CITY OF ALBUQUERQUE

January 7, 2021

Re: Restaurant
6000 Montgomery Boulevard
Traffic Circulation Layout
Engineer's/Architect's Stamp 1-4-2021 (G18-D042)

1 ARCHITECTURAL SITE PLAN

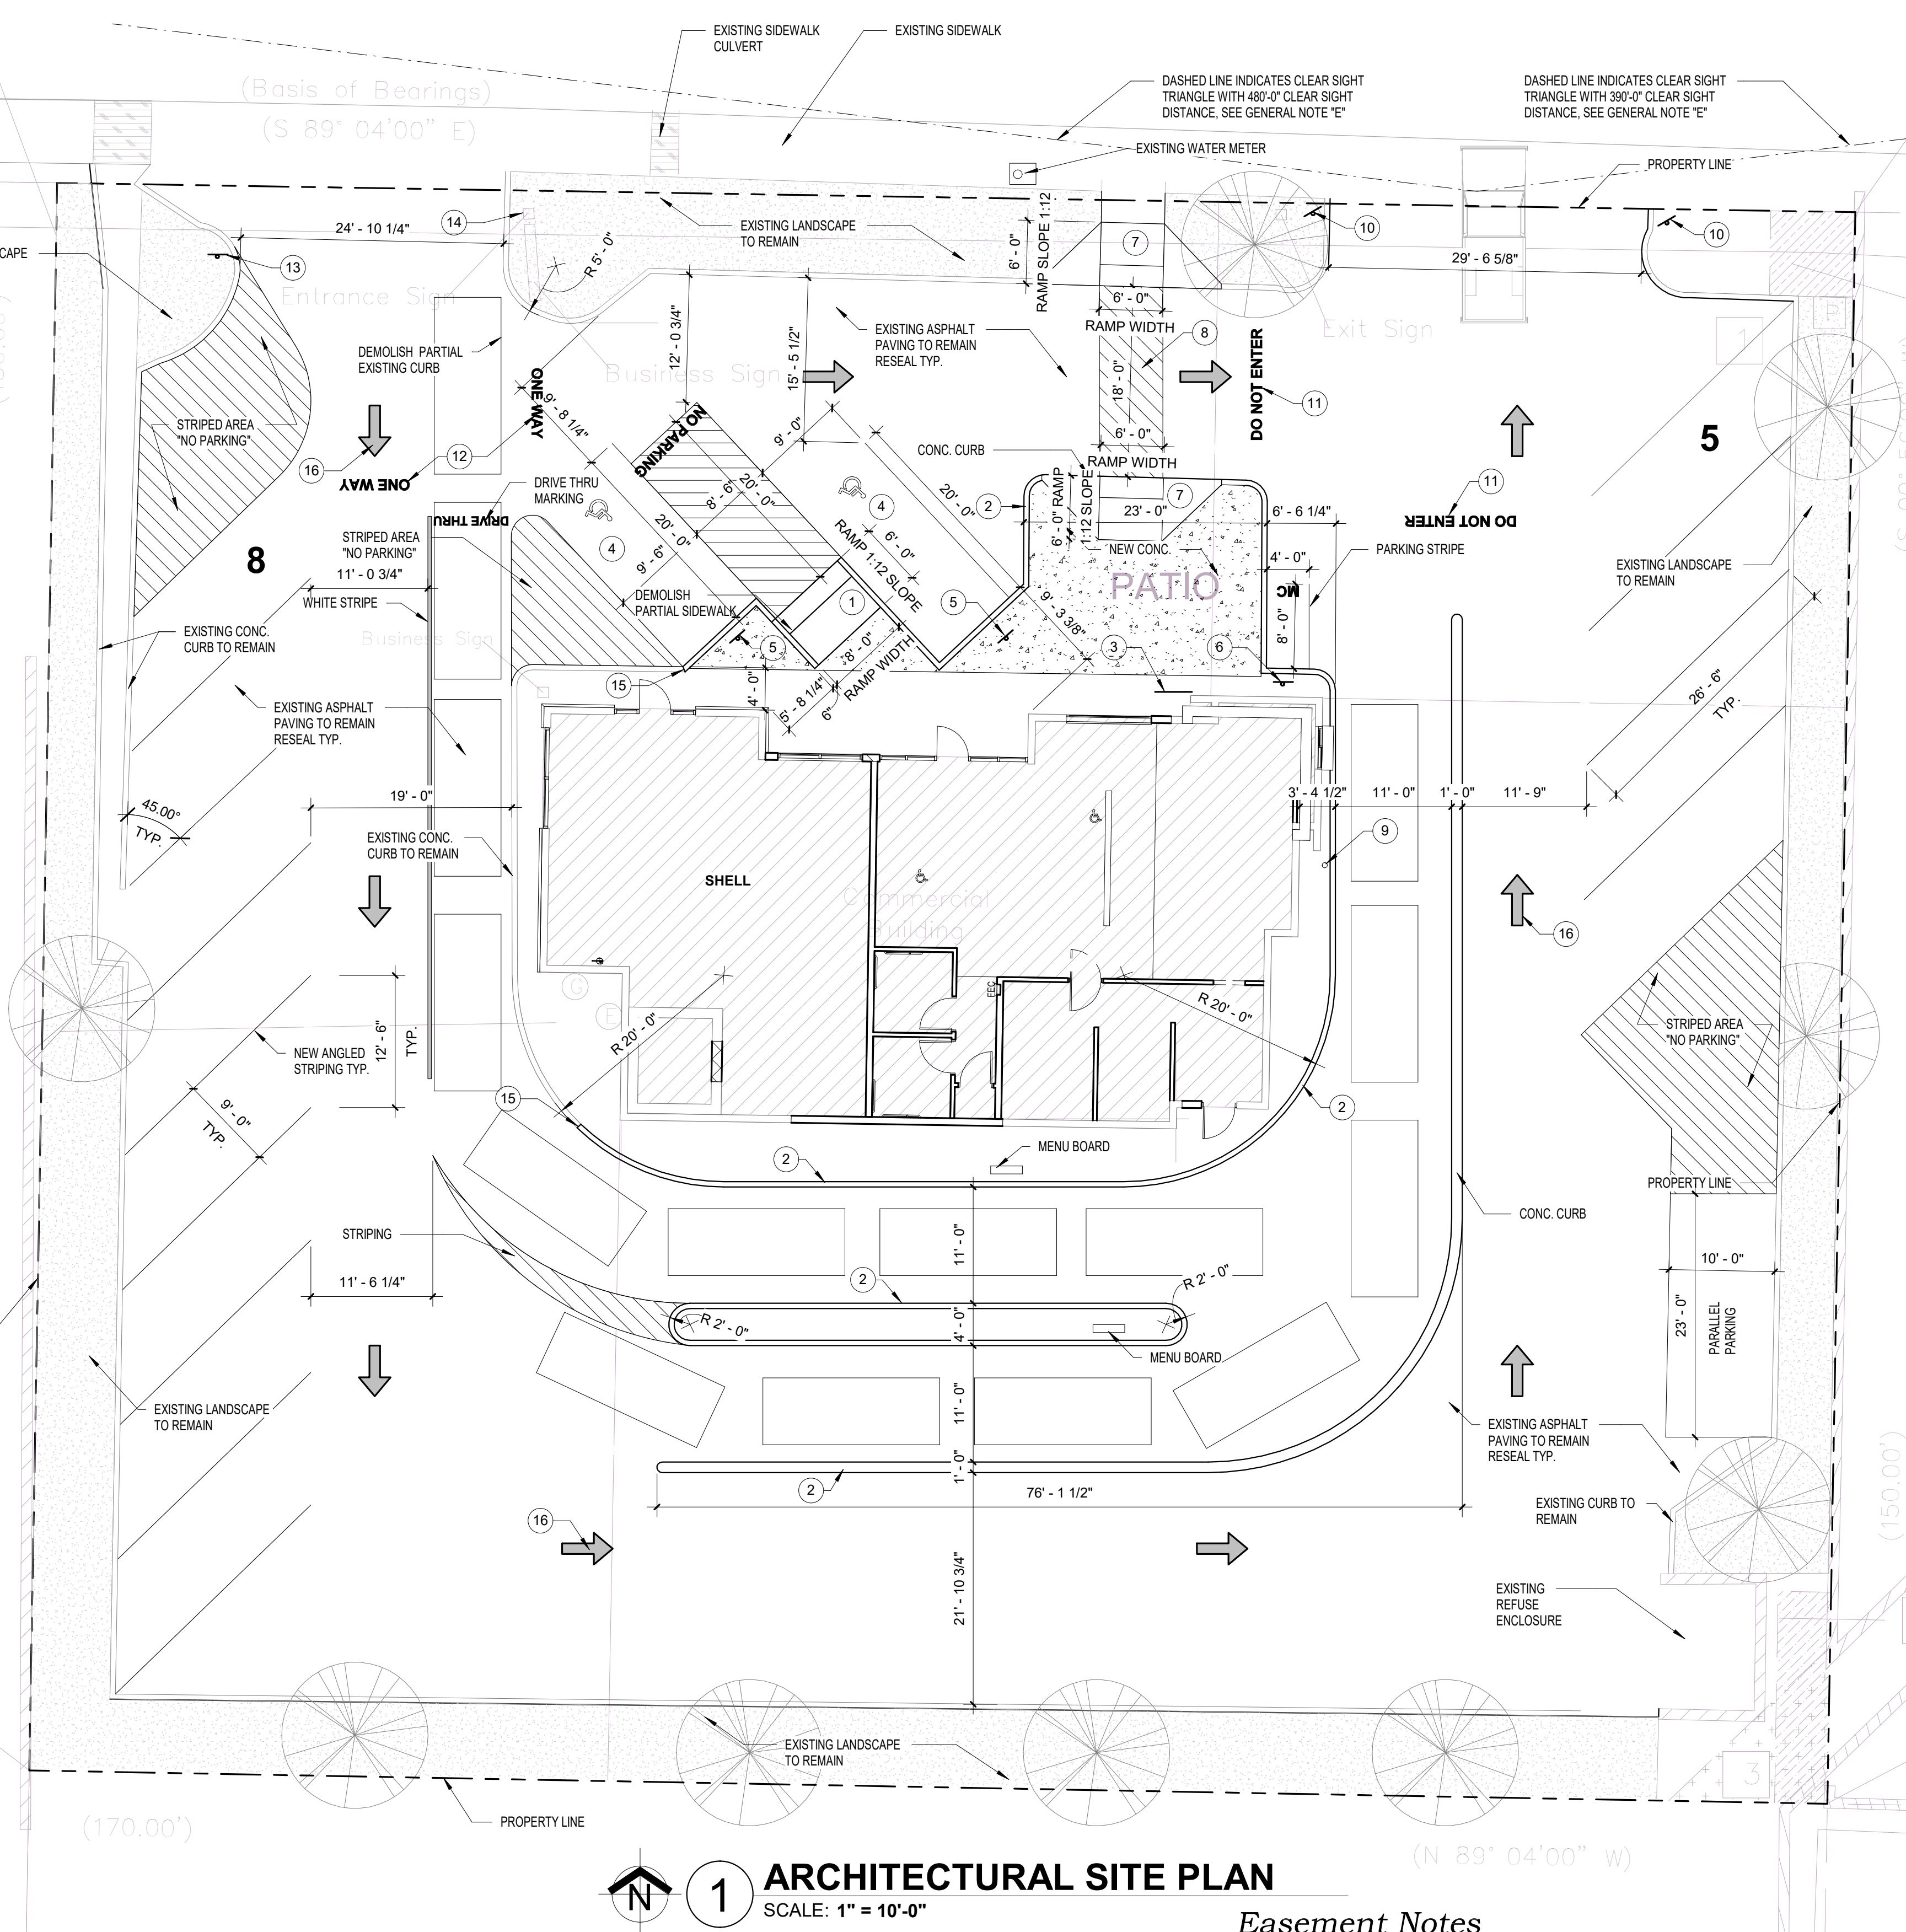
1. Solid Waste Approval is required prior to the Transportation Department's approval.
2. For the drive aisle along the west side of the property, provide a white stripe for the queuing. Mark "Drive-thru" for the pavement.

3. Provide dimension from the handicapped space to the curb along the north side of the parking lot. (This was the only aisle dimension that was missing where it may be a little tight.)

4. The plan shows curb across the sidewalk at each side of the exit drive to Montgomery. I don't think you meant to put curb here; I think you meant to just tie into the existing driveways for your new curb? Please distinguish between existing and new curb with call out notes, and specify where you are tying to existing.

5. For the curb ramp at the van accessible aisle, provide dimensioning, and show where curb/ramp begins and ends. Show how it matches the detail that is called out.

7. The pavement marking "MC" should be shown in the opposite direction for motorcycles entering the parking space.
8. To minimize conflict or confusion at the driveways, provide a restaurant entrance sign for the one-way aisle off of Montgomery Boulevard, or provide a one-way sign to make it clear that this is the entrance to the property. Add an additional "Do Not Enter" sign on the opposite side of the exit.

9. Label the pavement arrows with a keyed note.
10. Show the clear sight triangle for both directions of traffic, and be sure to follow diagram in DPM per AASHTO requirements. Add the following note to the plan. "Landscaping and signage will not interfere with clear sight requirements. Therefore, signs, walls, trees, and shrubbery between 3 and 8 feet tall (as measured from the gutter pan) will not be acceptable in the clear sight triangle."

PROJECT TITLE		ZIGGIS COFFEE SHOP		DRAWN BY:	
PROJECT MANAGER		JOB NO.	Project Number		
SHEET TITLE		ARCHITECTURAL SITE DETAILS			
DATE	12-31-20	SHEET			
SCALE:		AA1

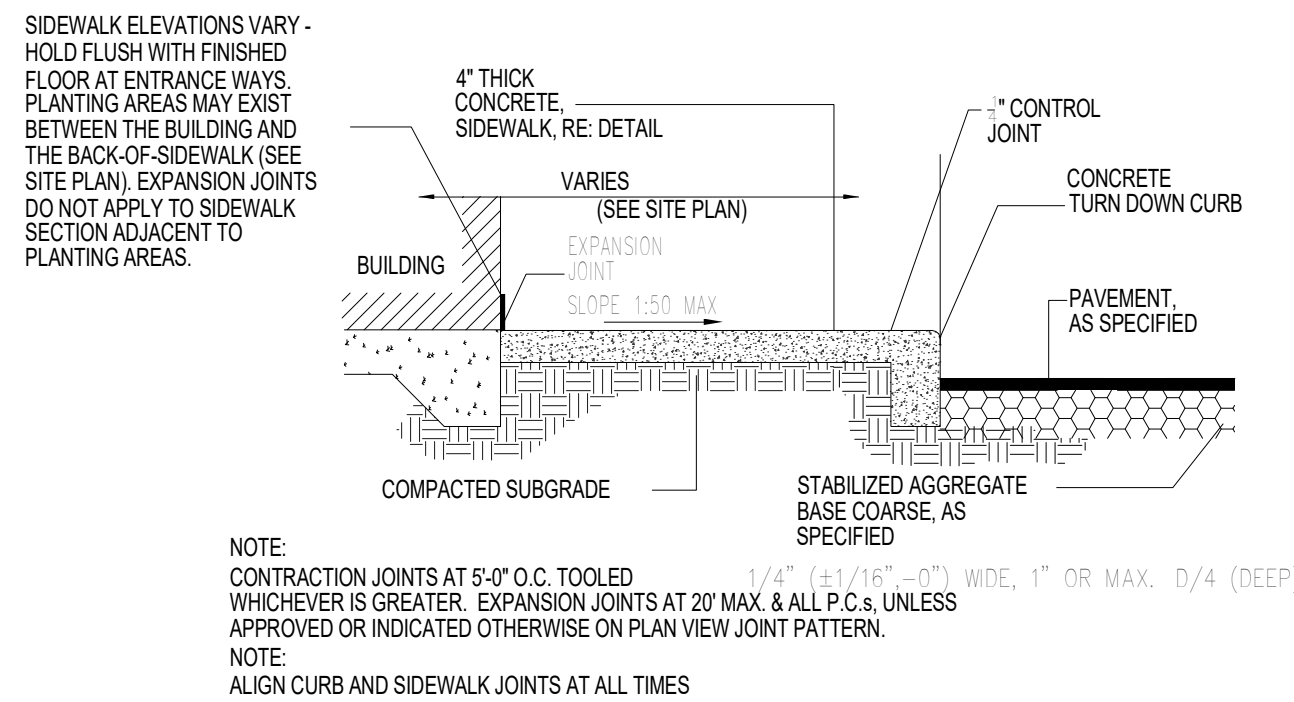
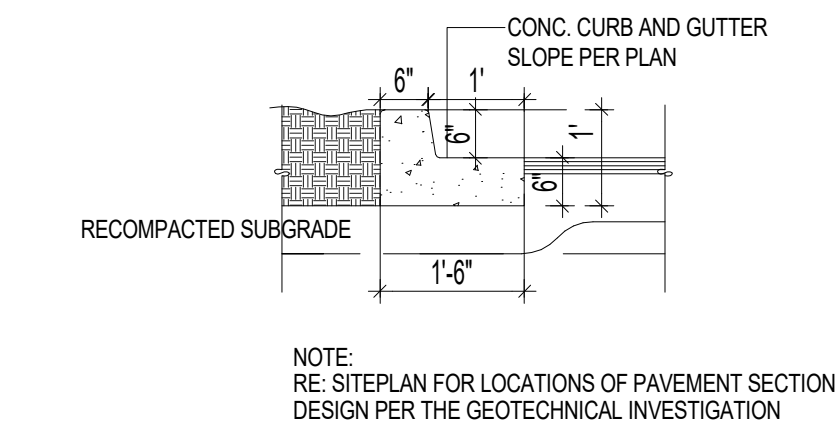
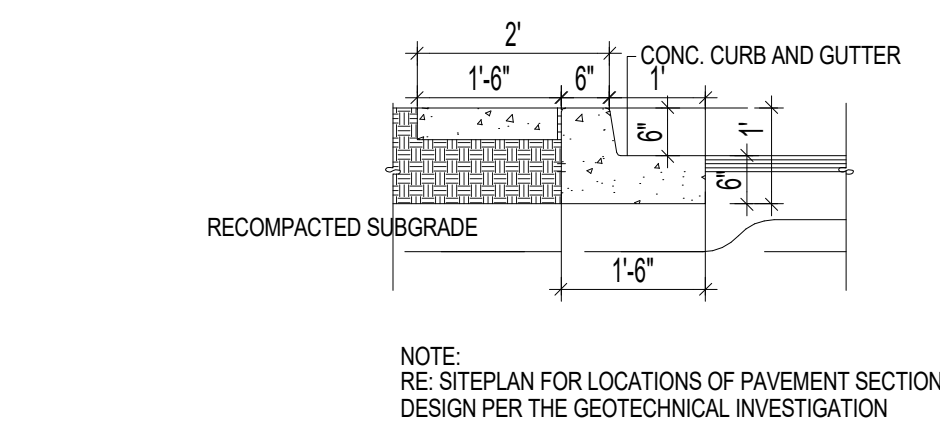
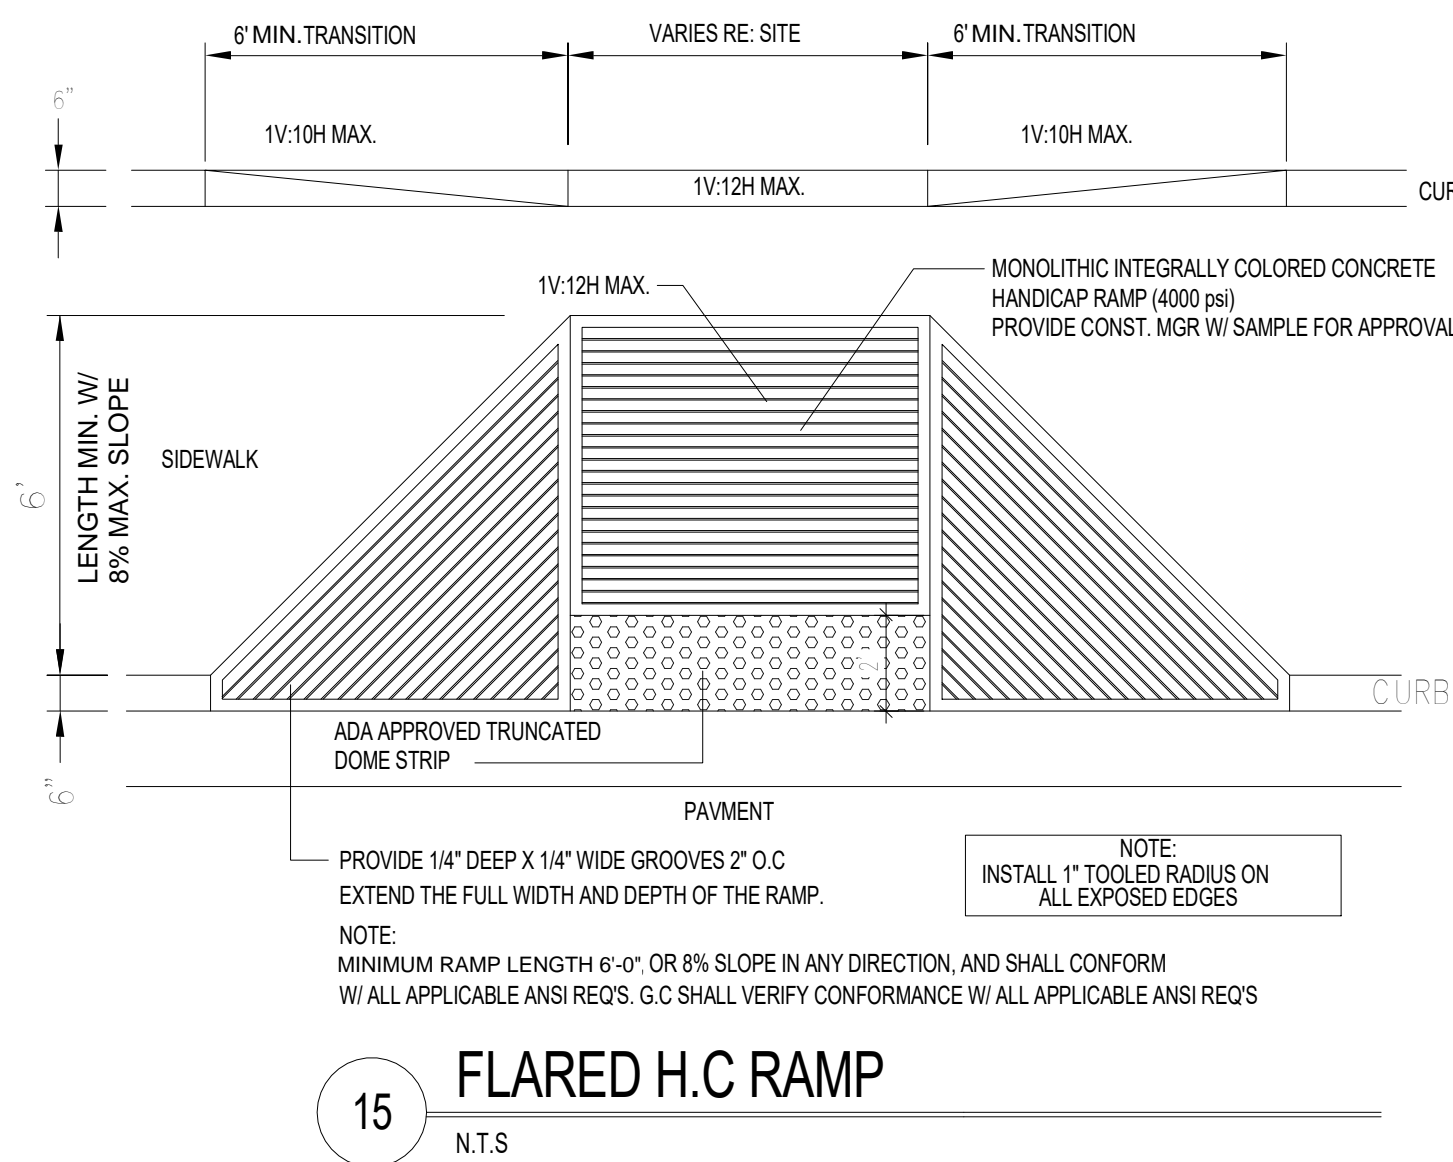
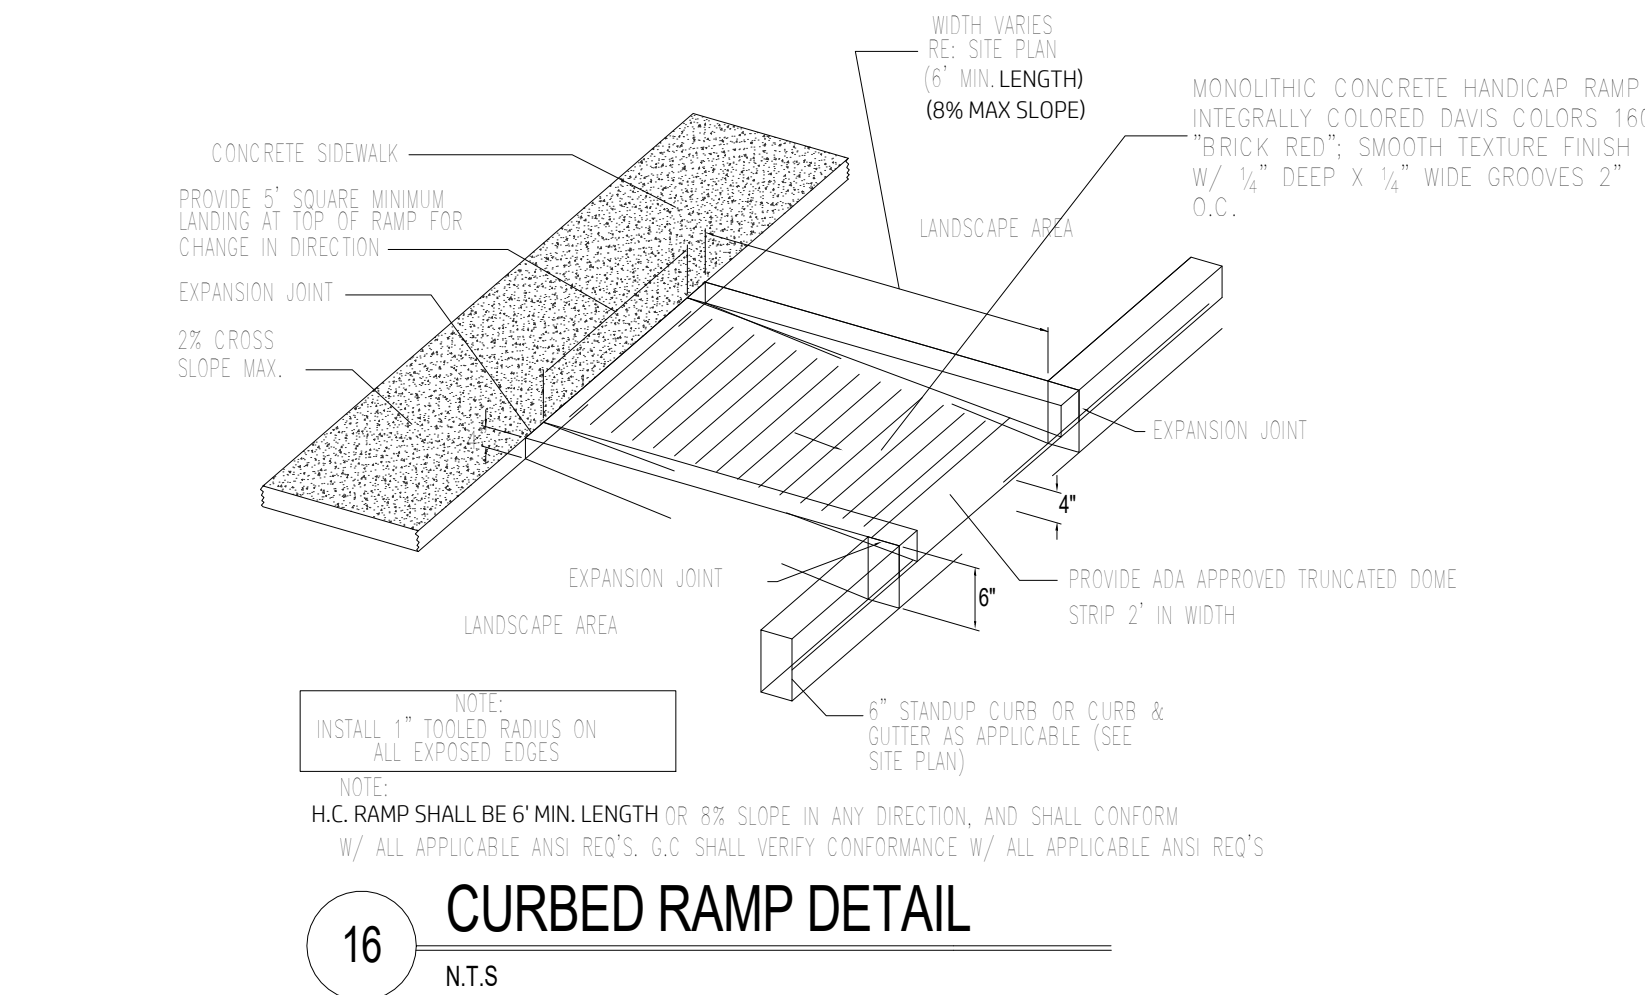
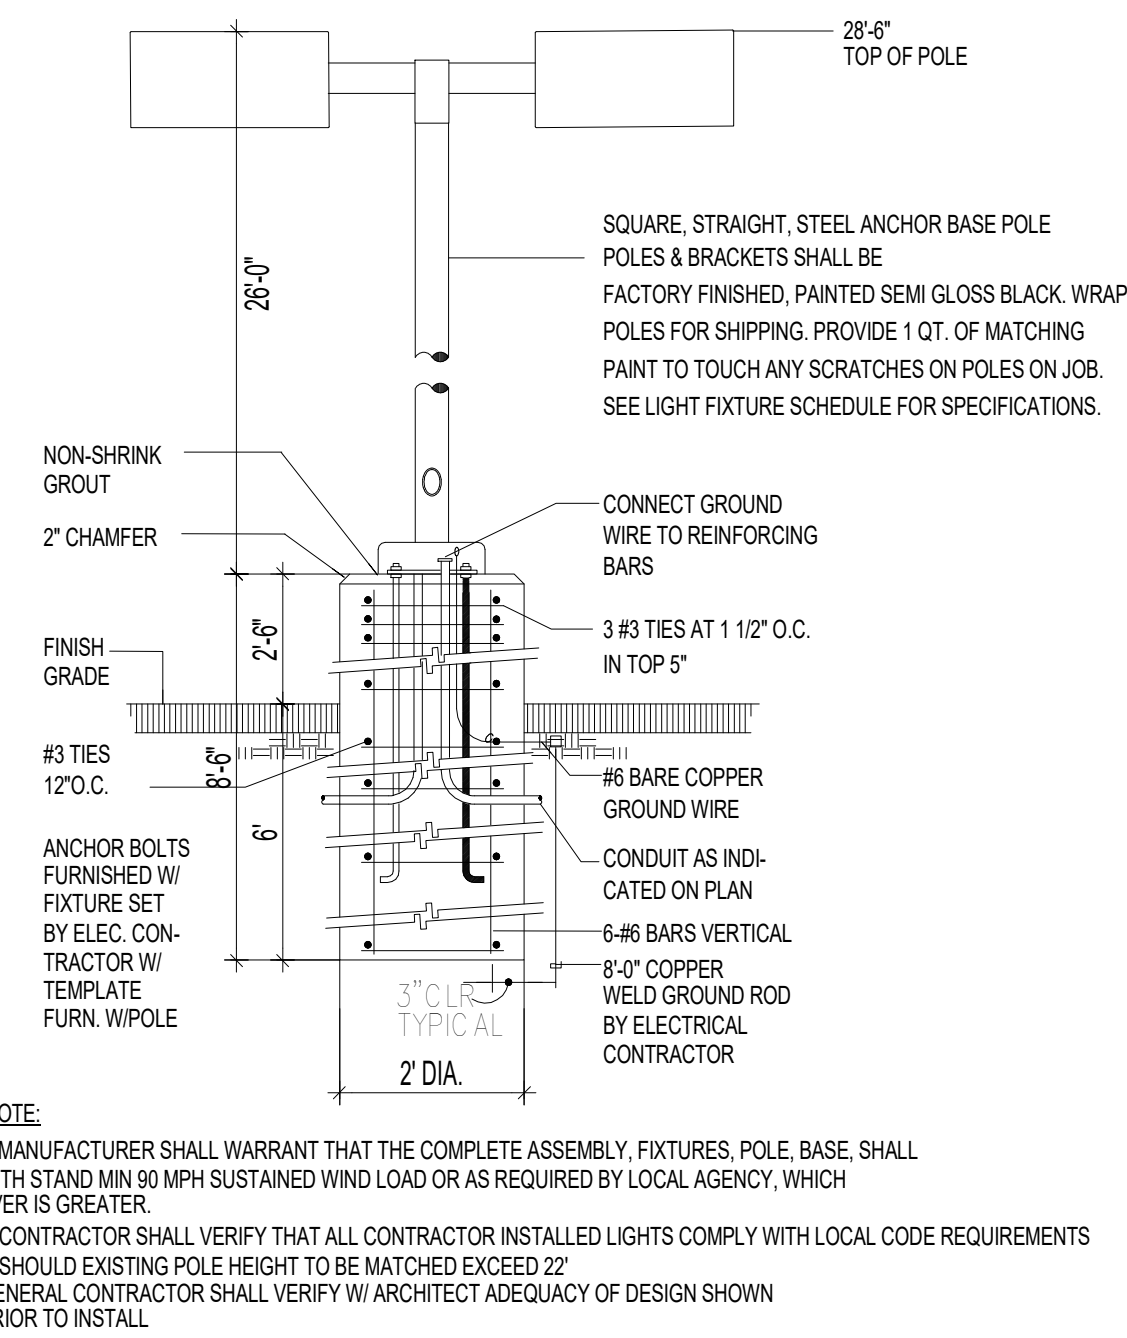
6. On the curb ramp details, it should show a 6-foot "minimum" dimension in lieu of a 6-foot "maximum" ramp length to ensure that the minimum slope of 12:1 is met. Also, delete any ramp details that are not being used.
